**Transport
for NSW**

Oakdale South Industrial Estate, Erskine Park (SSD 6917)

Thankyou for your letter dated 11 November 2015 regarding the above concept plan and development application.

GENERAL ARRANGEMENT PLAN

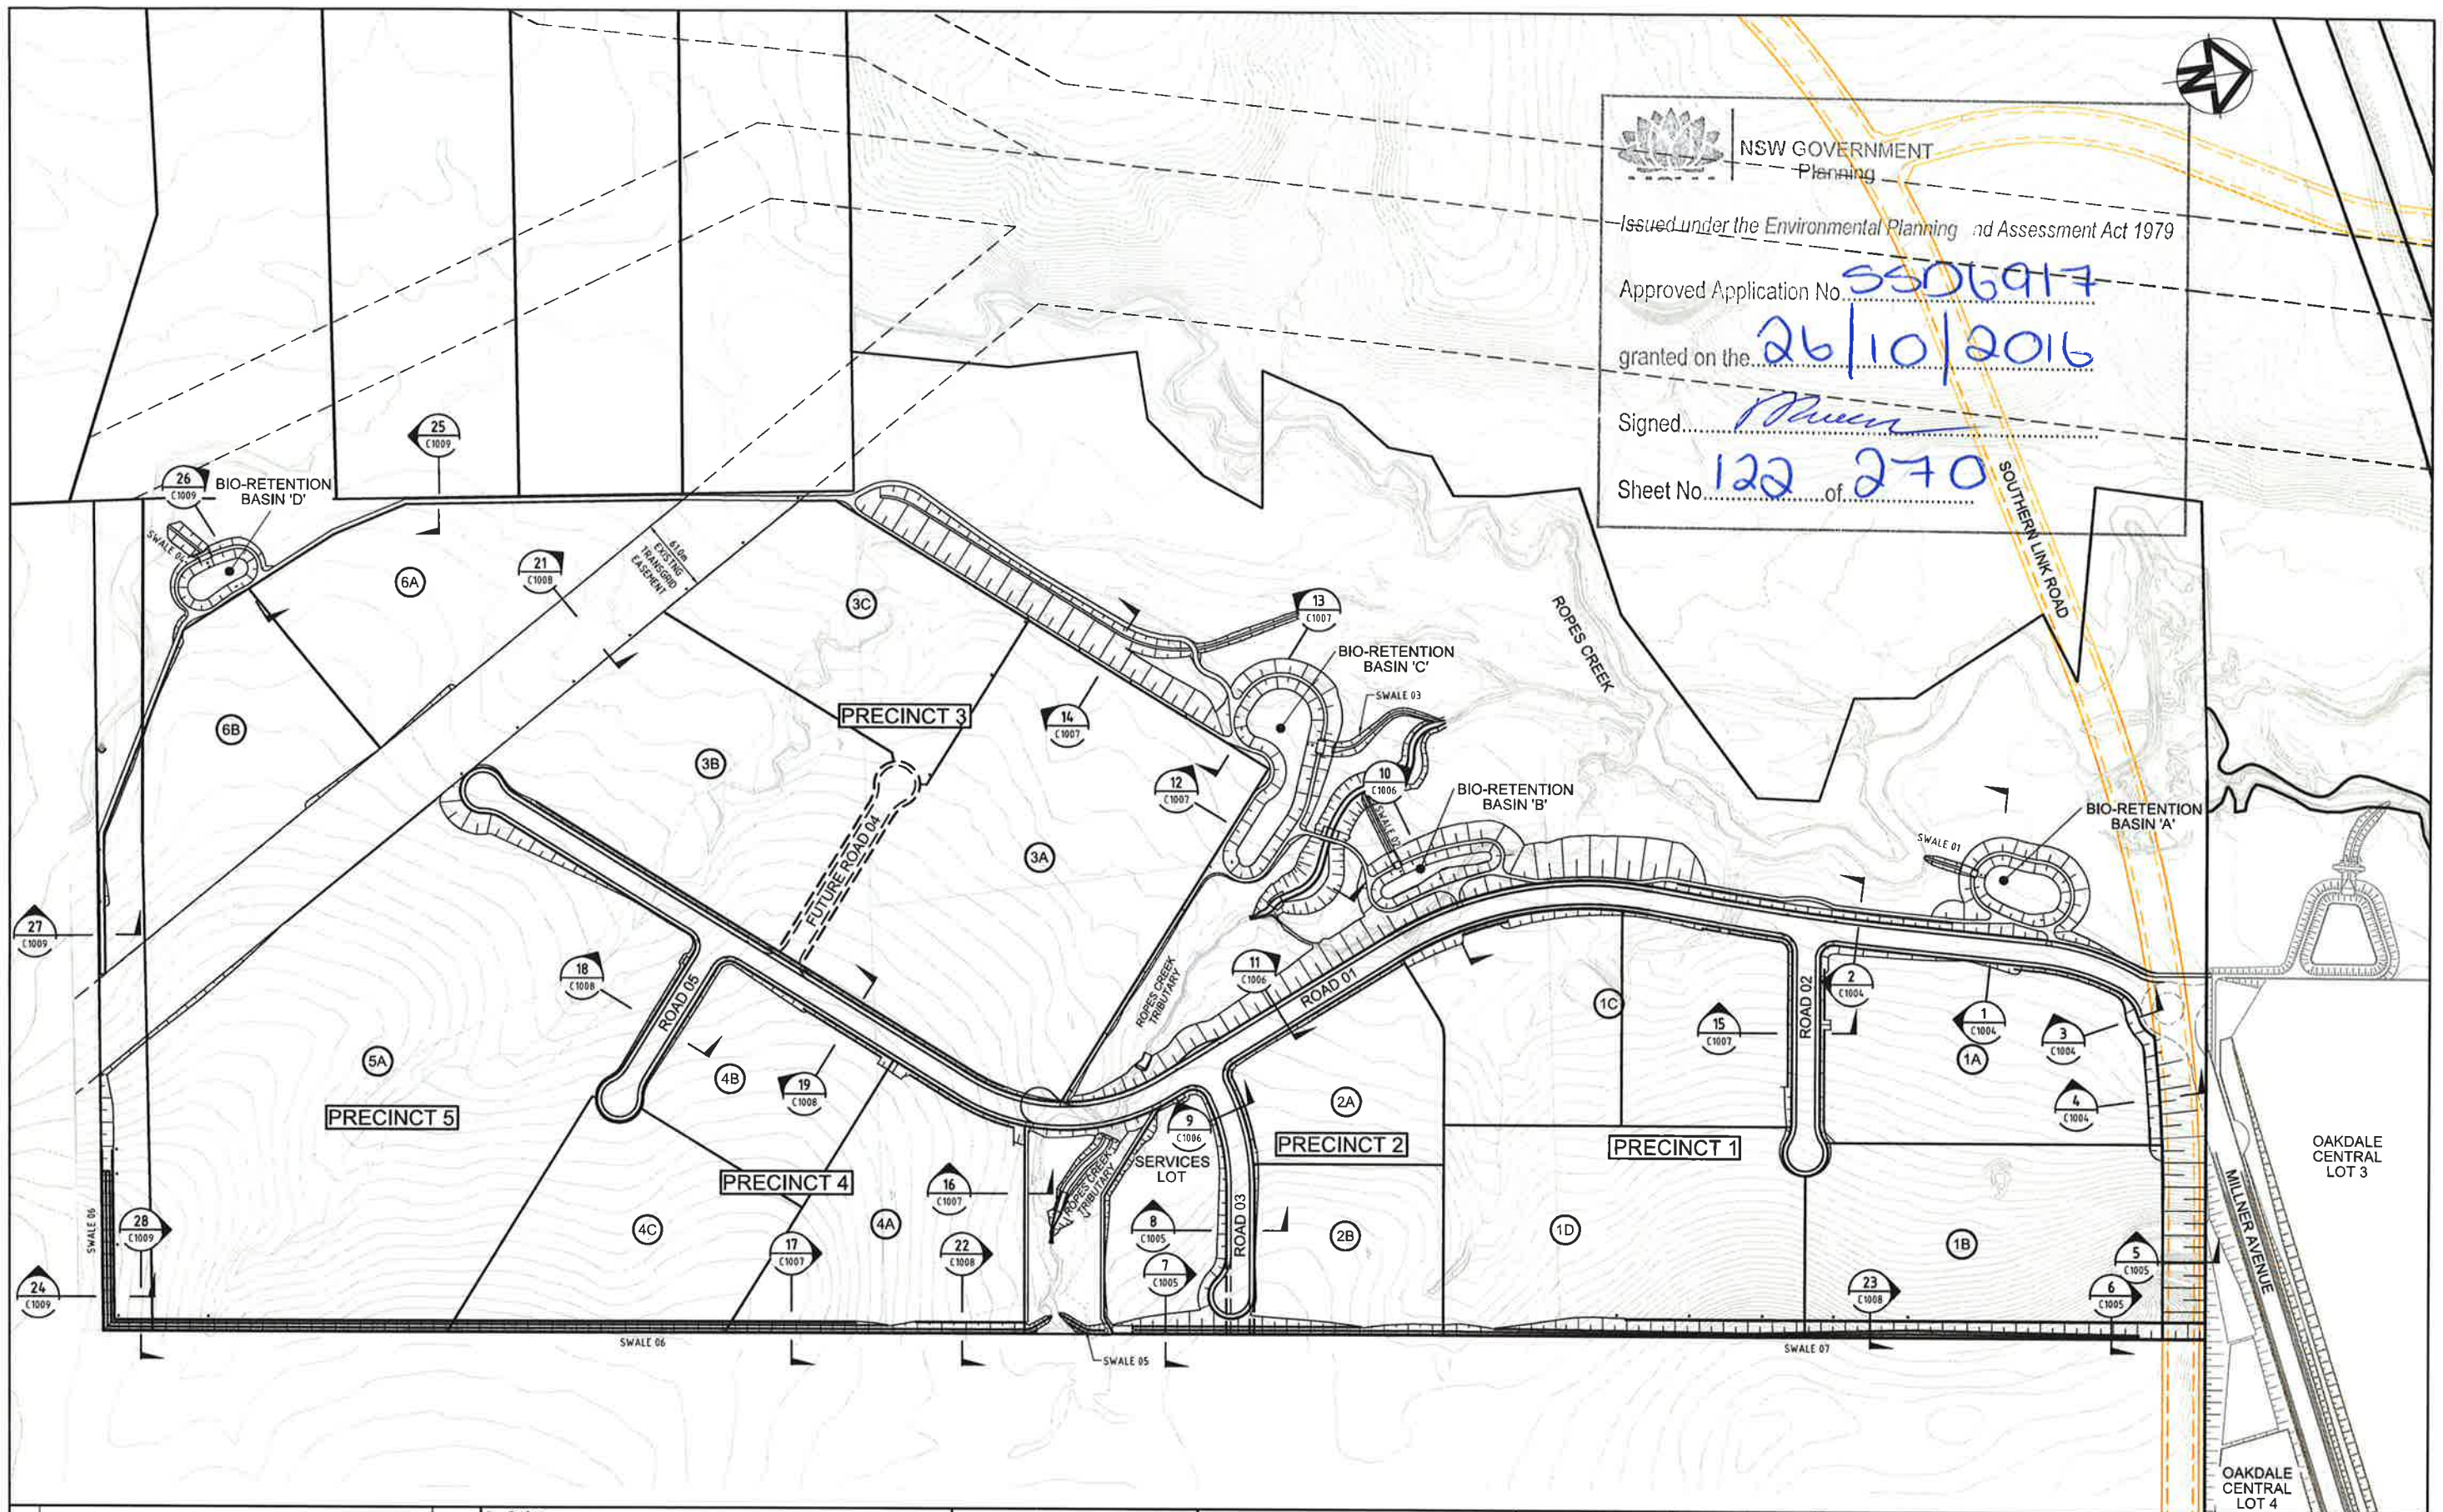
TfNSW note that the proponent is proposing to deviate the future alignment of the Southern Link Road in the vicinity of the site. TfNSW recommends that any road design changes to that exhibited in late 2014 should be consistent with previously adopted design standards.
